25th January 2013

Proposed creation of new 1st floor & raised tiled roof.

1 Downlands Close Pagham

sheet 3 of 5

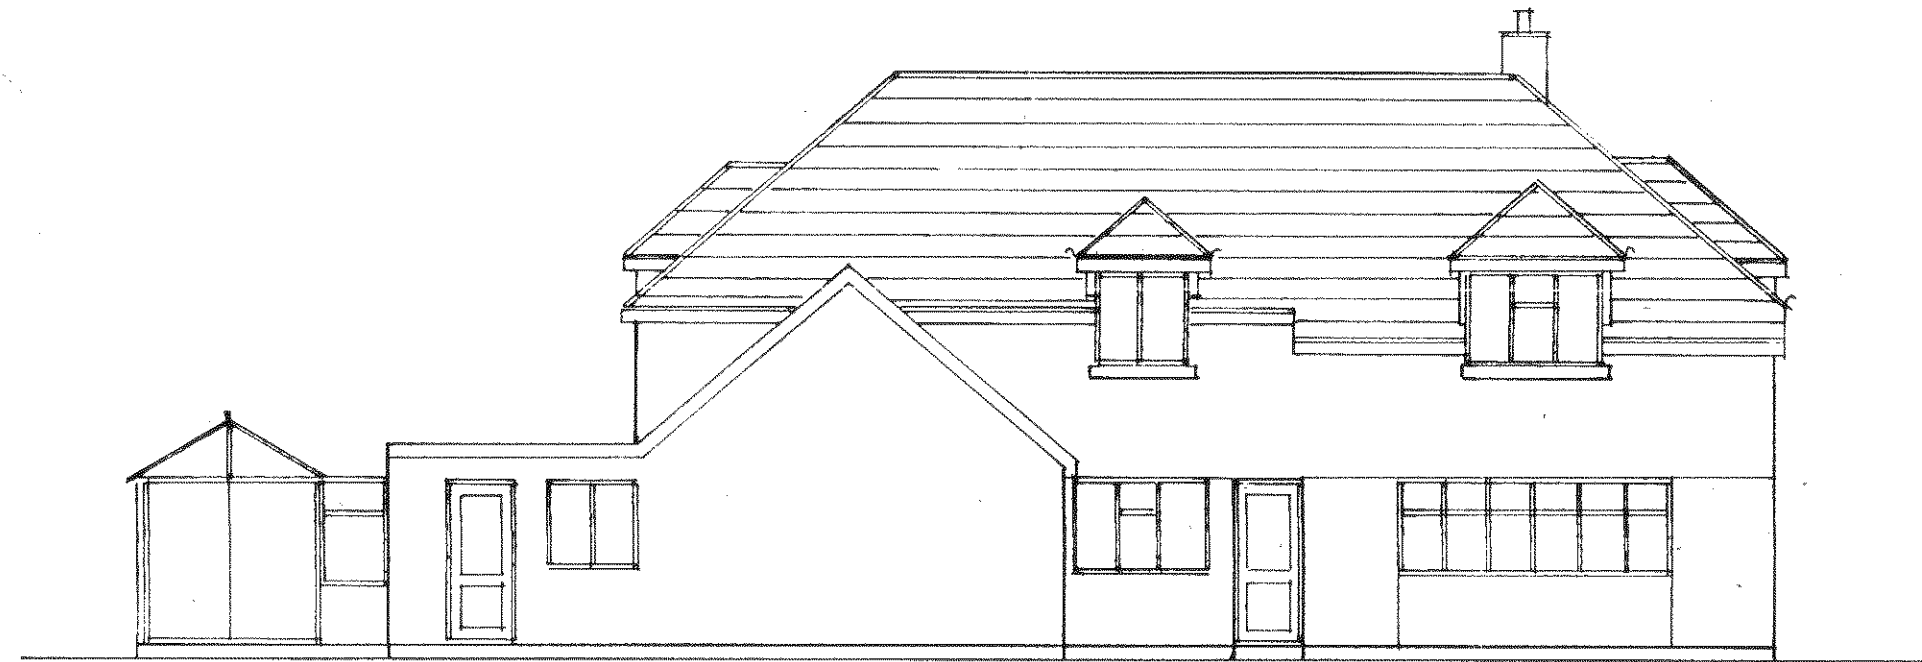
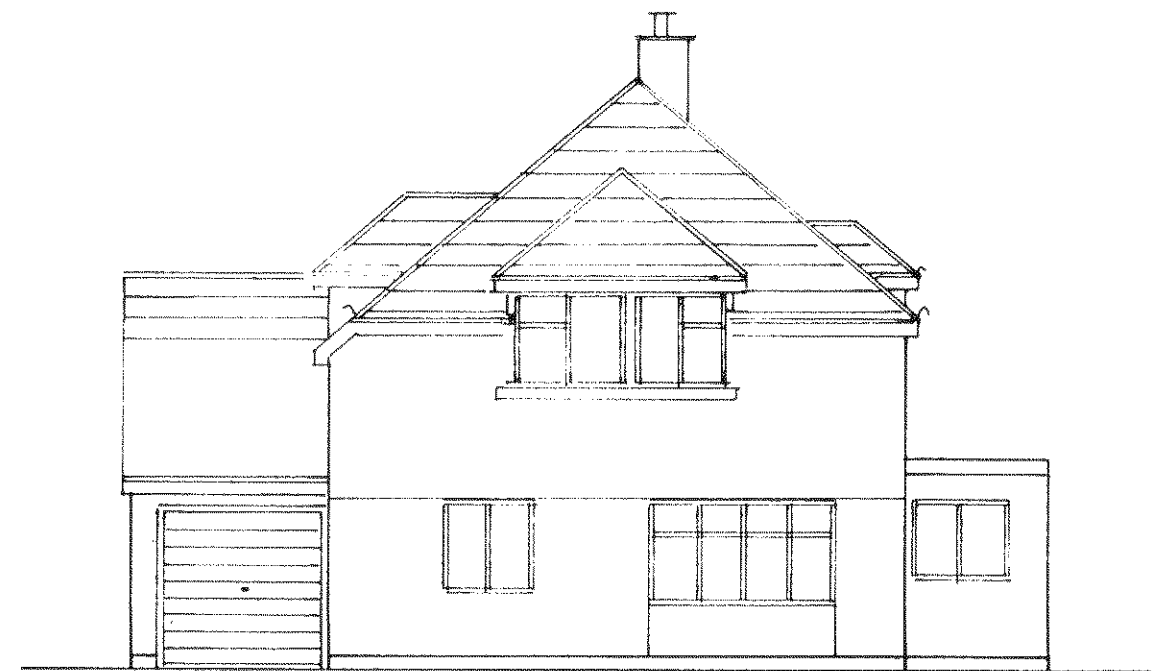
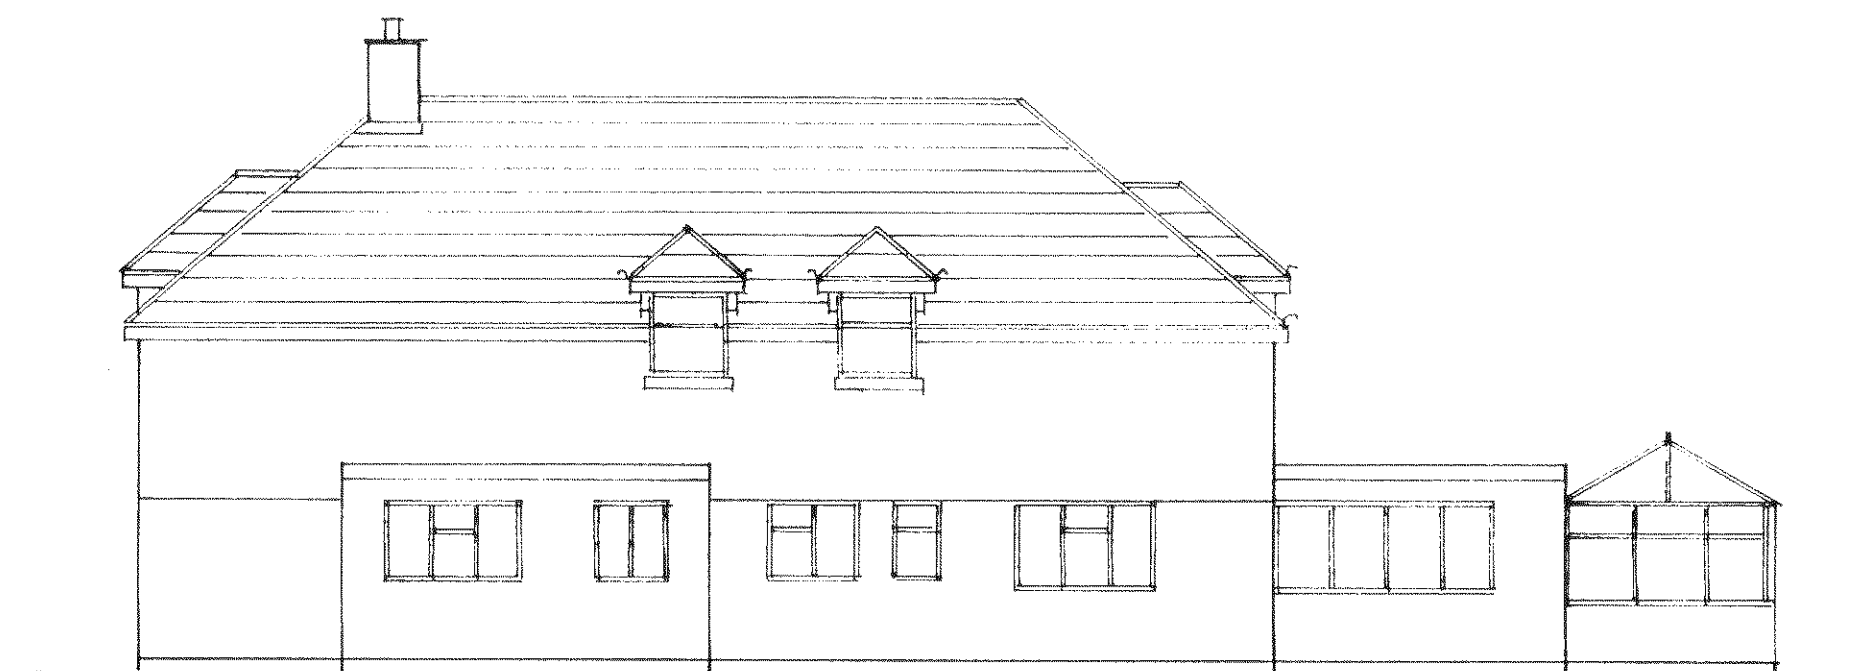
Comment was made of the height and bulk of the building being out of character with those in that locality, particularly in Downlands Close itself. Members reflected upon similar high level dormers consented at Fletcher Close having a seriously detrimental effect upon residents in Esher Close, which had been the subject of retrospective complaint to the Council by distressed retired folk at that location. Opinion was expressed that such a building would dominate the streetscape in an undesirable way at that entrance to the built up area of the village of Nyetimber which has been claimed to possess its own discrete and ordered identity.

Dev 19 (ii) ∴ visually subservient to the main building ∴, (iii) ∴ adverse ∴ overlooking or overbearing effect on neighbouring properties ∴, (v) ∴ does not compromise established spatial character and pattern of the street ∴
